East Anglia TWO Offshore Windfarm

Change Request: Amendment to Order Limits at Work No. 9 (Plot 13)

Applicant: East Anglia TWO Limited
Document Reference: ExA.AS-1.D9.5.V1
SPR Reference: EA2-DWF-ENV-REP-IBR-001104

Date: 22nd April 2021
Revision: Version 01
Author: ScottishPower Renewables and Royal HaskoningDHV

| Important Hedgerows and Tree Preservation Order Plan Sheet Number: Sheet 2 of 12 | | | Rev | 5 | British National Grid OSGB36 |

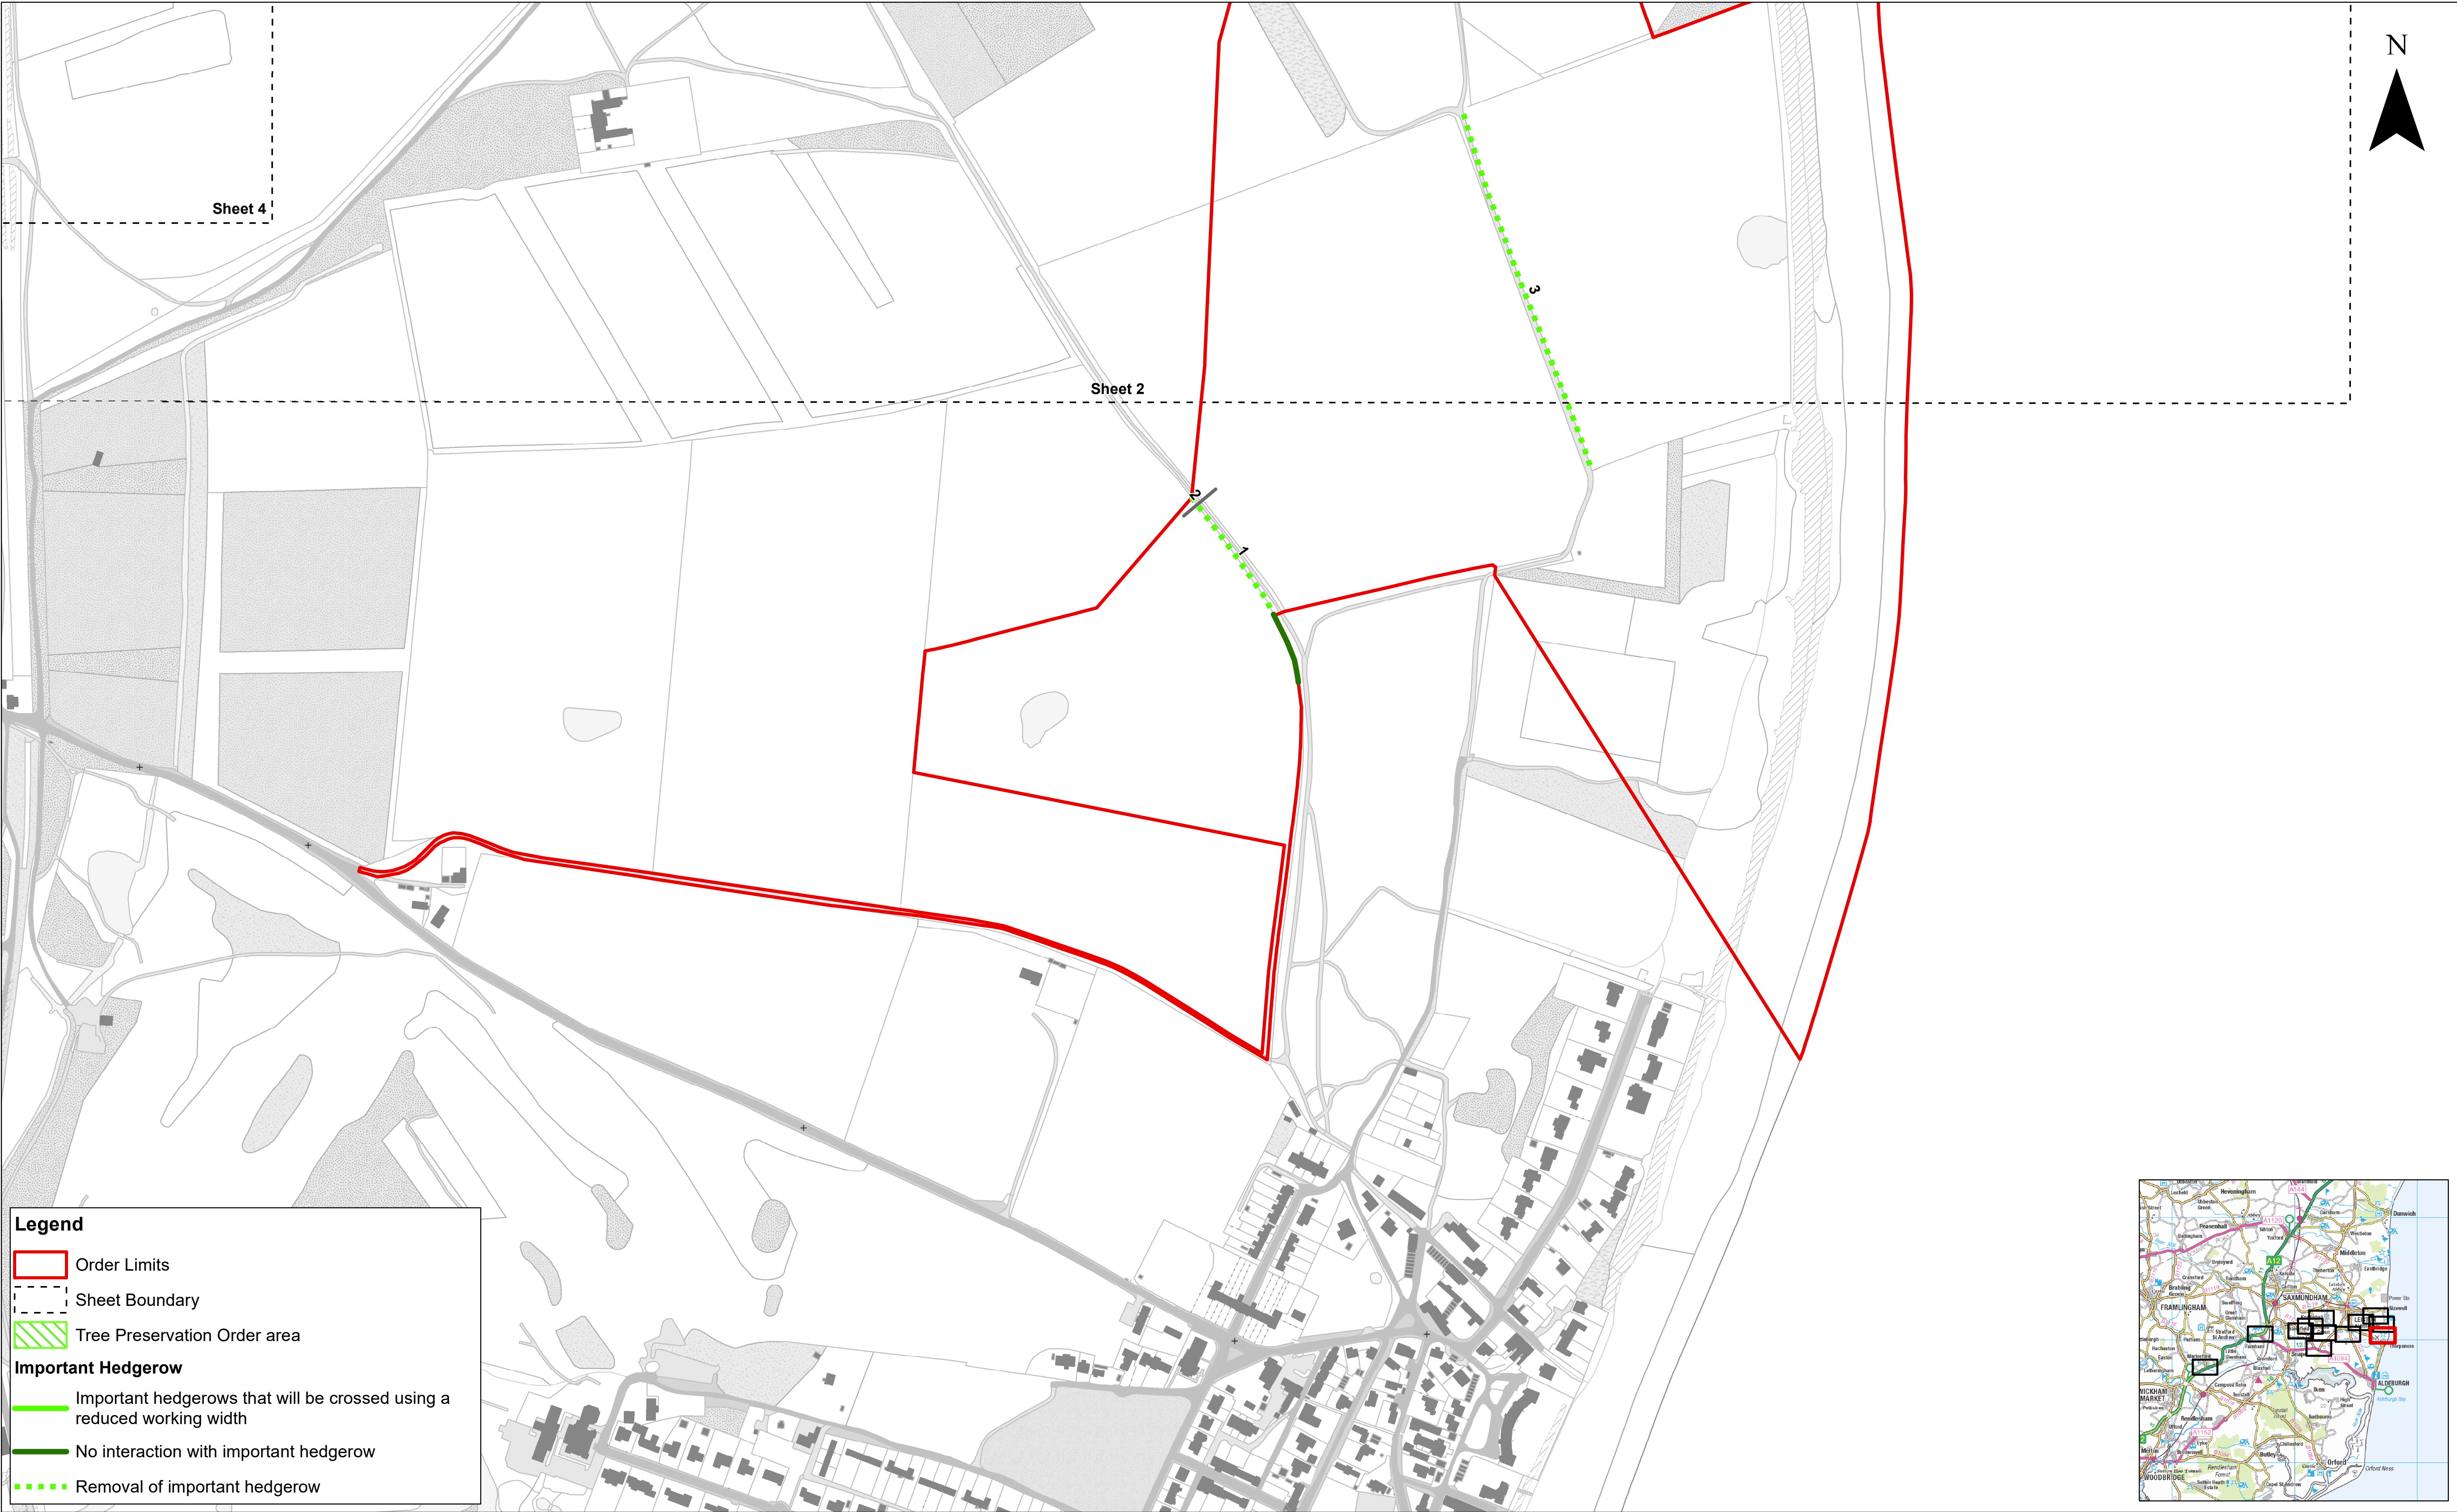
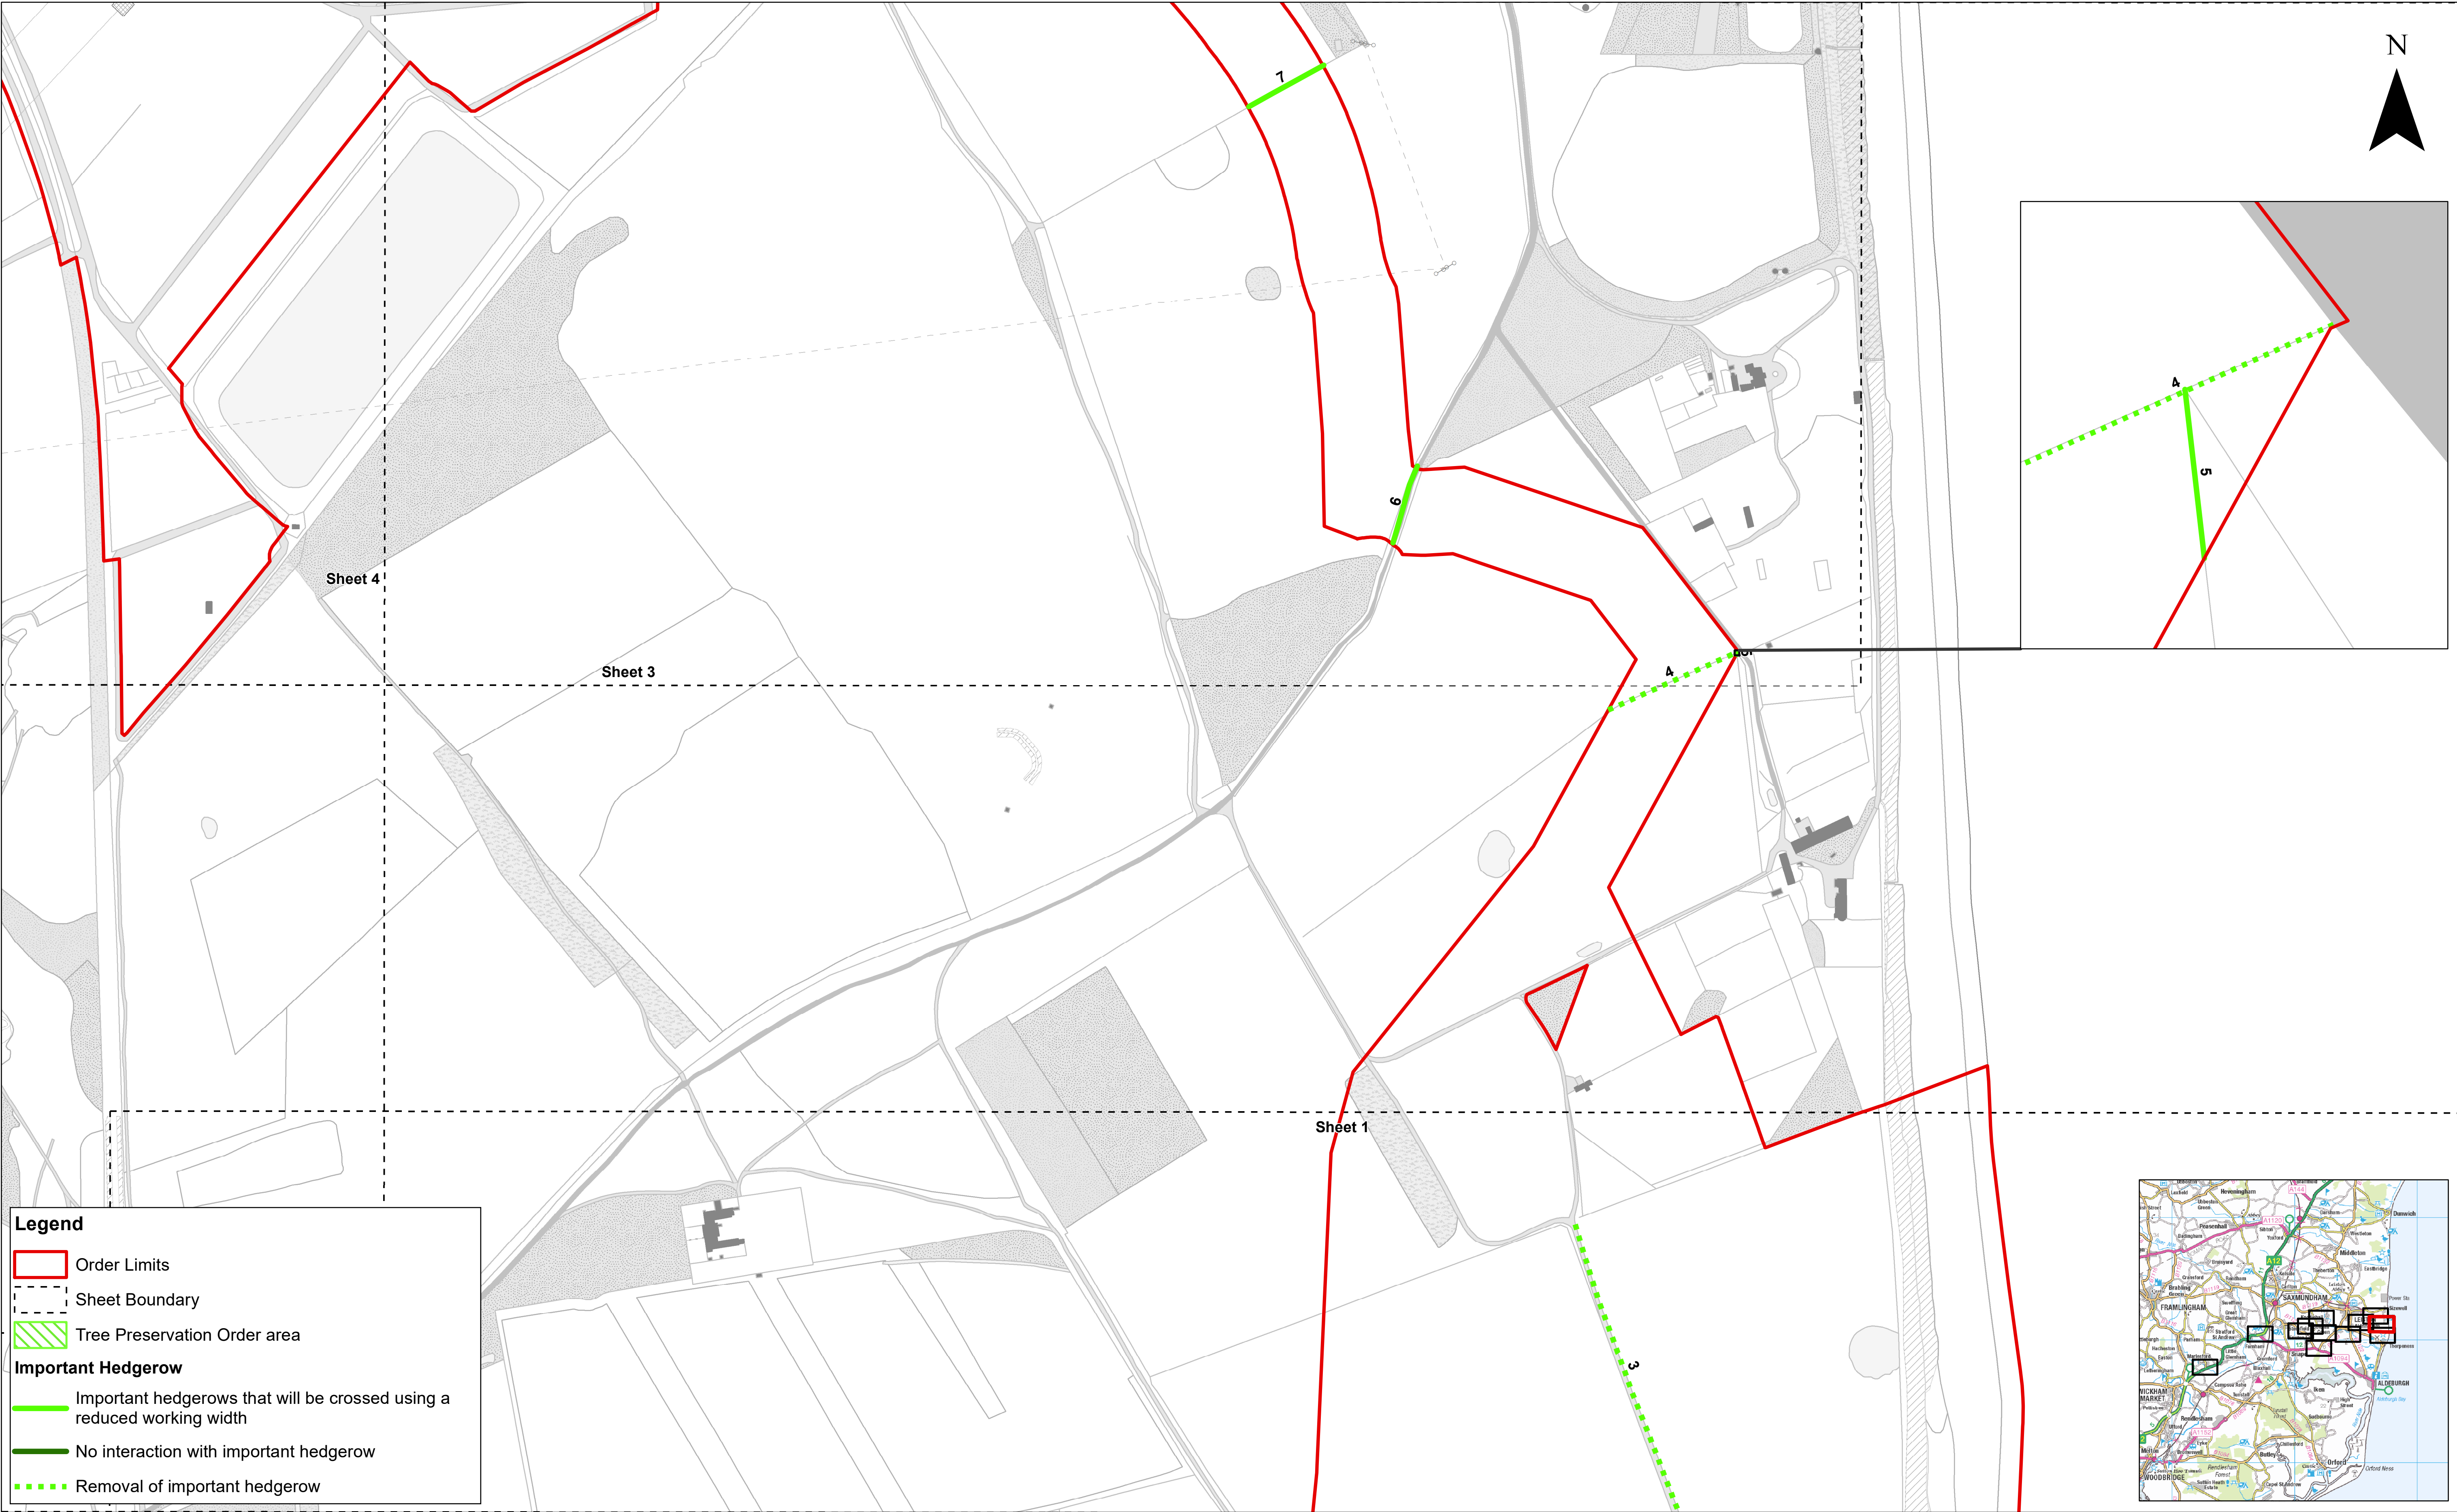
14. Given the revised alignment of the onshore cable corridor at this location, the crossing of important hedgerow 4 (shown on the **Important Hedgerows and Tree Preservation Order Plan** (document reference 2.10)) will be undertaken at a reduced width of 16.1m per project. Additionally, there will no longer be a need to remove any part of important hedgerow 5.
